Our Ref: D2016/141219

**Western Coal Services Project Modification 1 (SSD 5579)
Review of Statement of Environmental Effects**

I refer to the Statement of Environmental Effects (SEE) for the modification of the Western Coal Services consent SSD 5579. The modification application seeks permission to allow receipt of the residuals from the proposed Springvale Water Treatment Plant project.

Figure 4-1 Cumulative probability distribution of discharges via LDP006

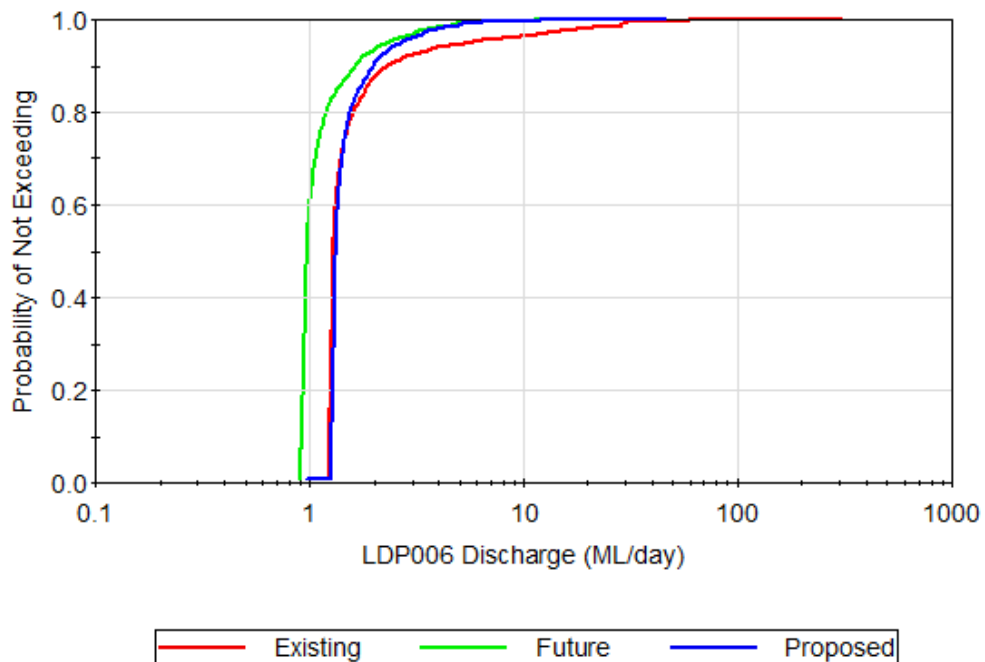
- Appendix D, Page 39, Section 5.1.1 and Figure 5-3 states discharges from LDP006 range from 0-14 ML/day. While salinity loads for average annual discharges have been estimated, salinity loads and consequences for higher end of discharges are not estimated. WaterNSW considers these should be estimated and impacts on Wangcol Creek assessed.
